CITY OF PORTLAND, MAINE

March 24th, 2016

Project Name: **Construction of new four-unit residential condominium building**
Level III Subdivision and Site Plan
Project #: #2016-005
Address: 31 Fore Street, Portland
CBL: 016 J026001
Applicant: Peninsula Property Development
Planner: Jean Fraser

DRIVEWAY APRON LAYOUT DETAIL
NOT TO SCALE

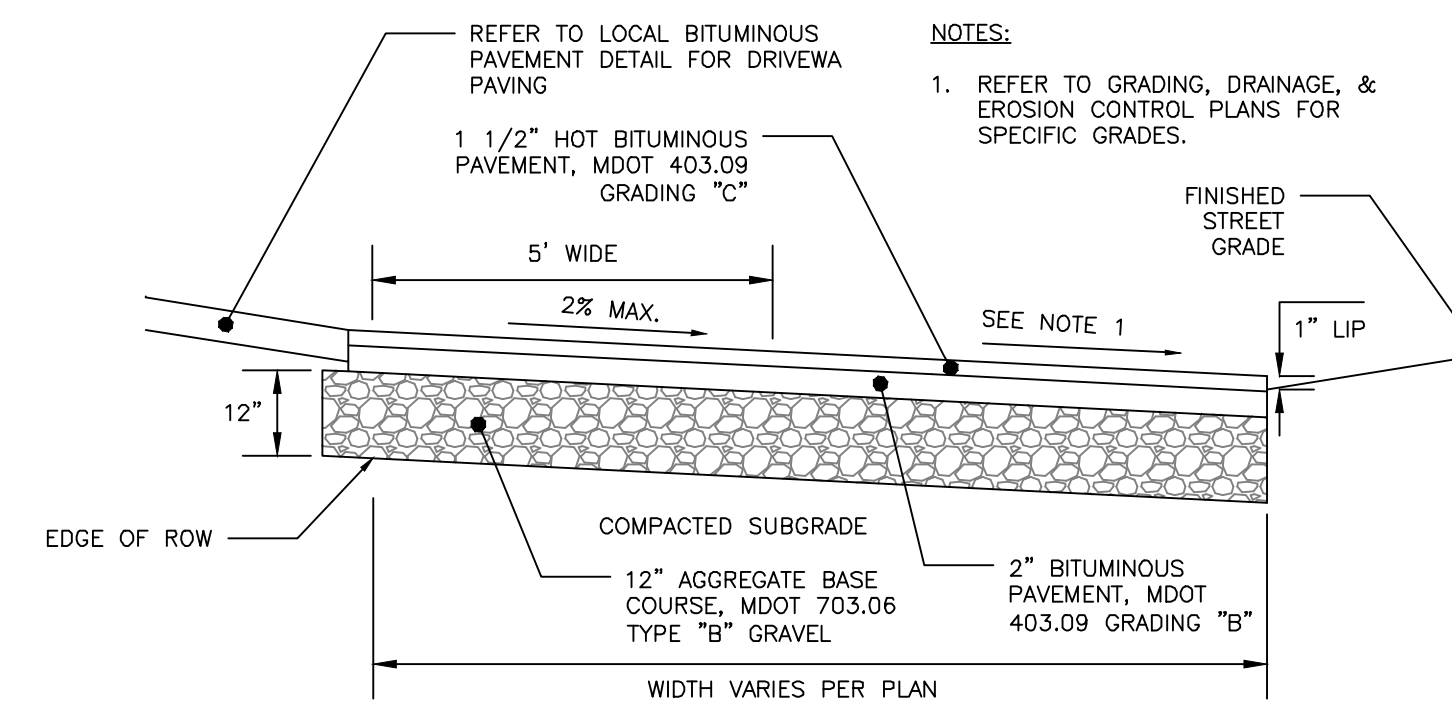
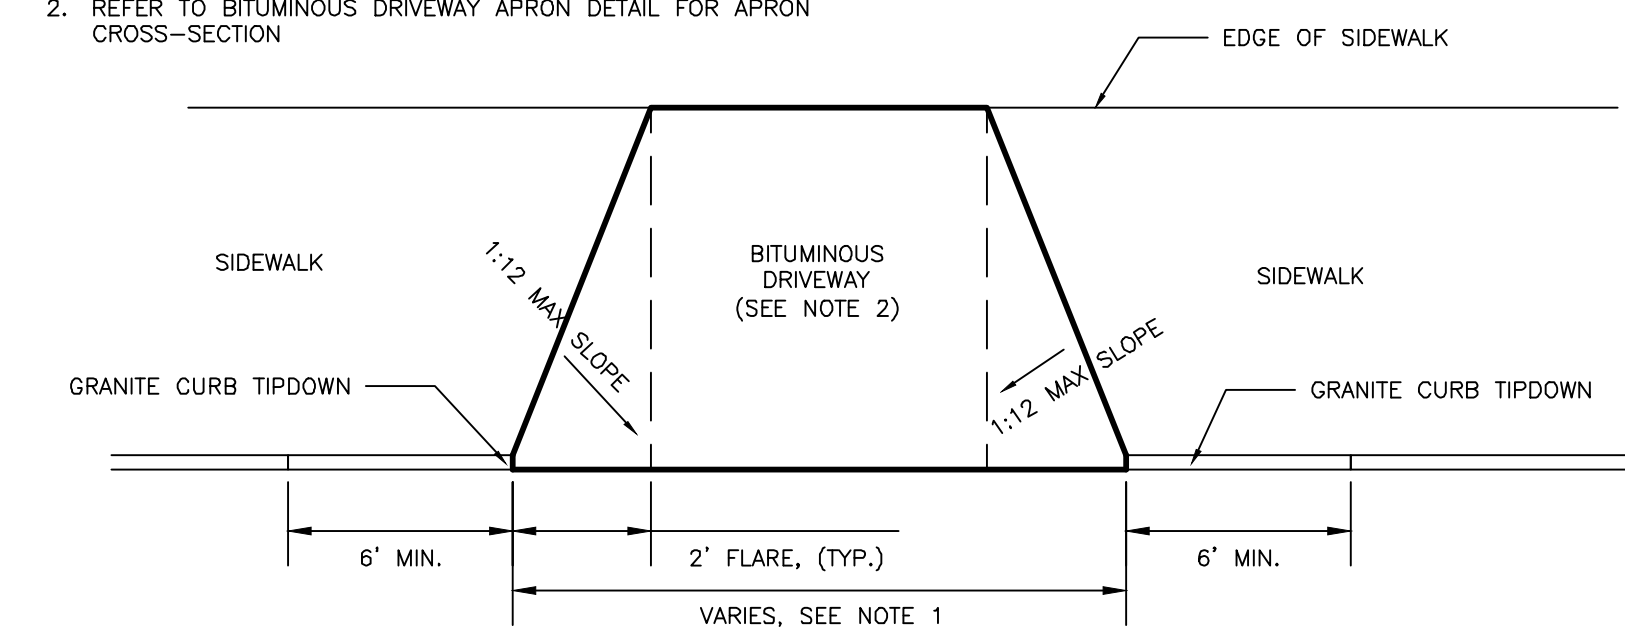
The planning board voted 7-0, based upon the consulting traffic engineer and DPW reviews, that extraordinary conditions exist or undue hardship may result from strict compliance with the *Technical Manual* standard 1.7.1.7 that requires "access driveways to corner lots shall be located a minimum of 35 ft from the intersection of the projection of right-of-way lines to the center line of the driveway", that substantial justice and the public interest are secured with the variation in this standard, and that the variation is consistent with the intent of the ordinance. The planning board waives the *Technical Manual* standard (*Section 1.7.1.7*) to allow the access driveway to be 31.26 feet from the intersection based on an understanding that the driveway location is constrained by the architectural requirements.

- vi. That the applicant shall submit a revised on-street parking layout that takes account of the relocated curb cut for review and approval by the Planning Authority prior to the issuance of a Certificate of

**BICYCLE HITCH DETAIL**  
NOT TO SCALE

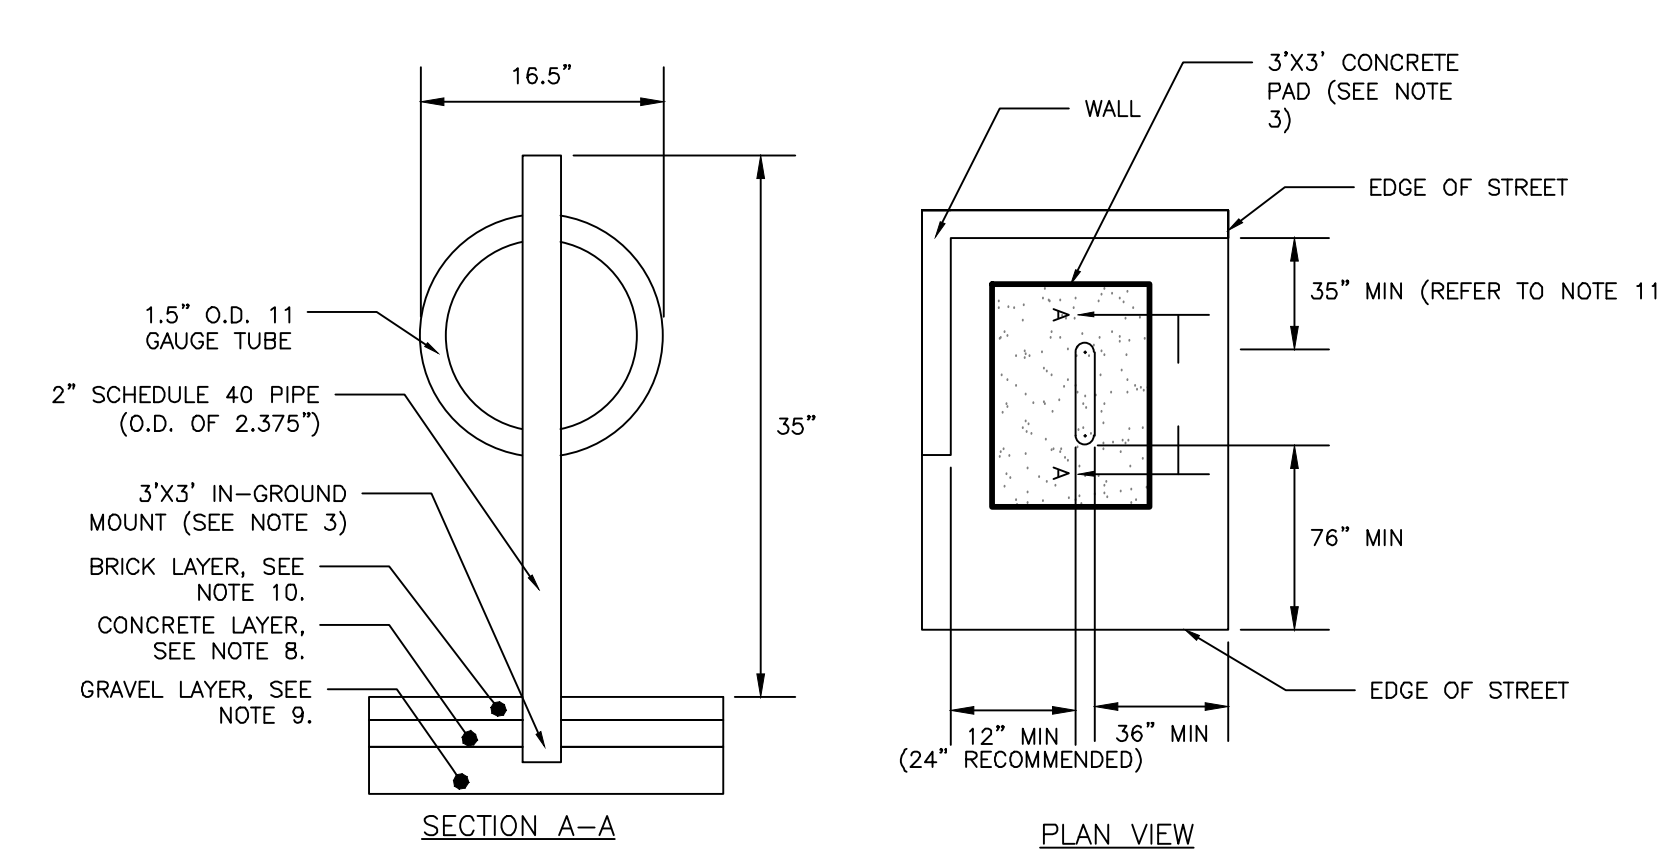
- b. Ensure that the bicycle parking hitches in the ROW are designed to meet the Technical Standards; and
 - c. Show that the design of the balconies will direct drainage and ice/snow so that it will not fall on the sidewalk.

**PARKING SPACE DIMENSIONS**  
NOT TO SCALE

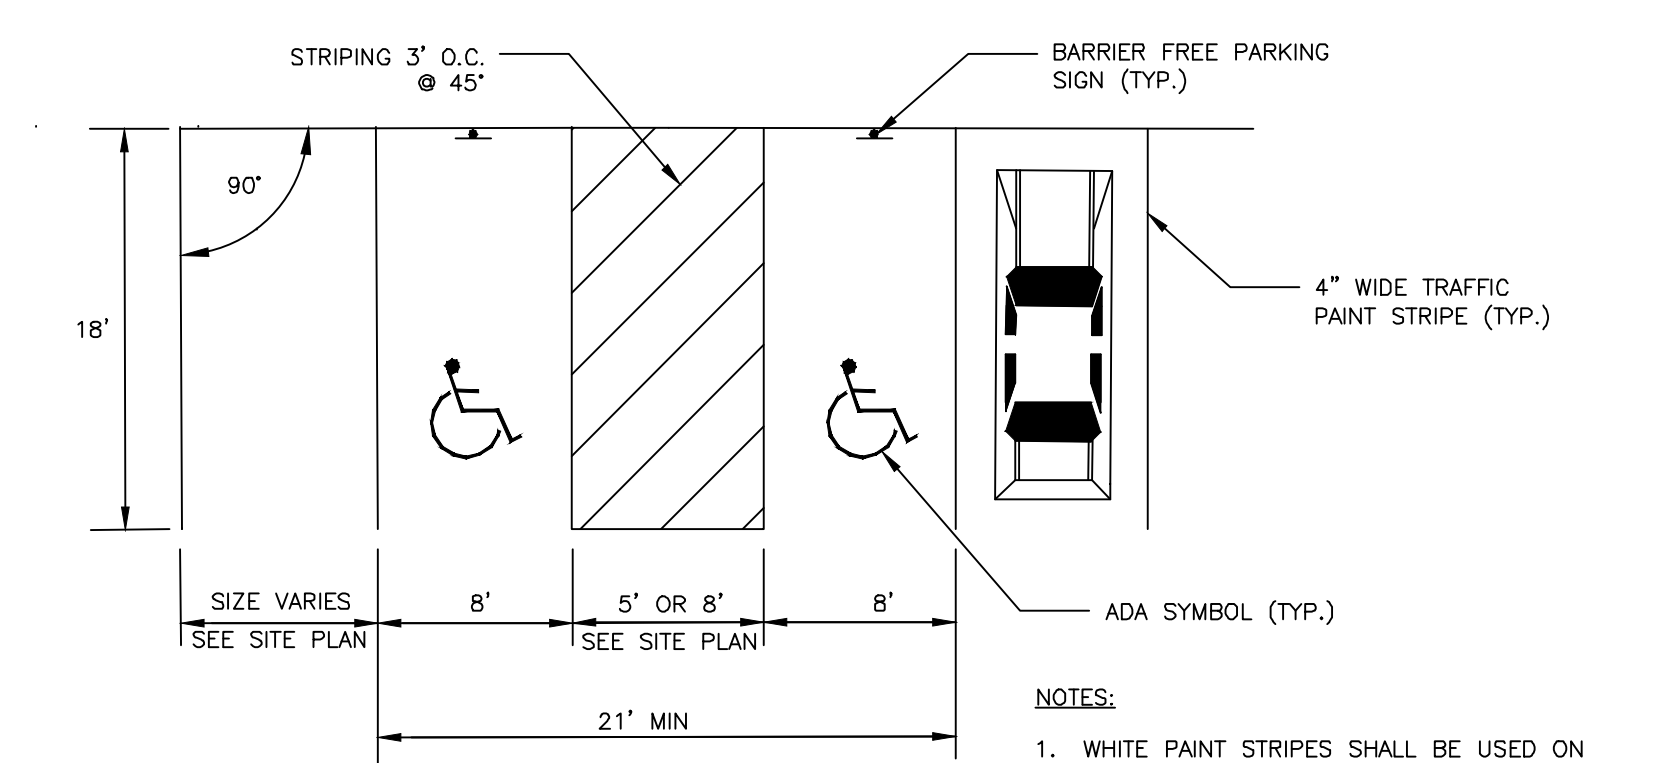
- vii. That the applicant shall submit a revised parking layout within the parking garage to show an ADA compliant parking space, for review and approval by the Planning Authority prior to the issuance of a building permit. The applicant may convert up to 2 spaces to be less than standard size and may reduce the number of parking spaces to meet this requirement, subject to meeting zoning requirements and satisfying the Traffic Engineer regarding operation.

**TREE PROTECTION DETAIL**  
NOT TO SCALE

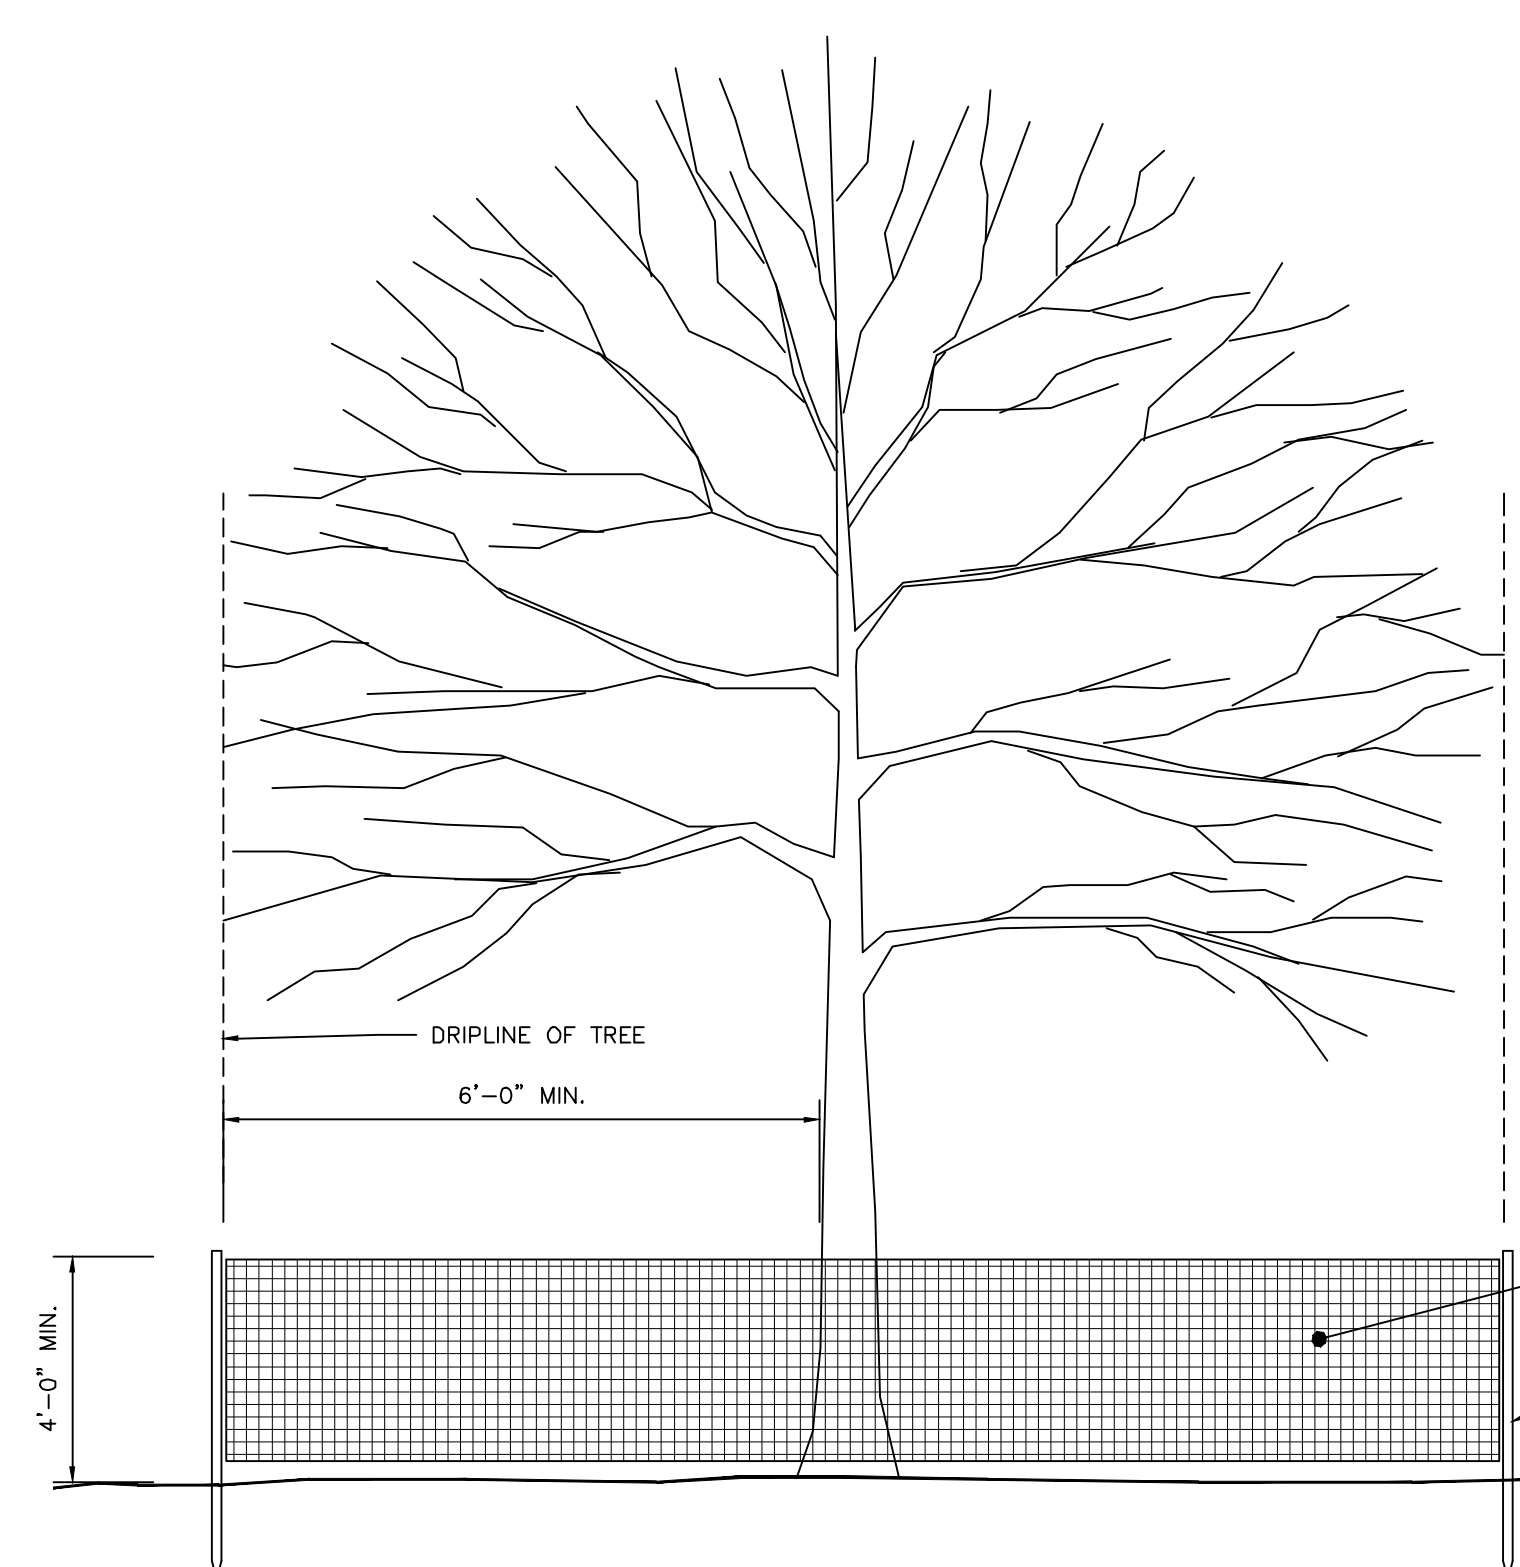
- iv. That the applicant shall take all measures to protect the existing street tree on Fore Street as recommended in the City Arborist comments dated 3.16.2016; and
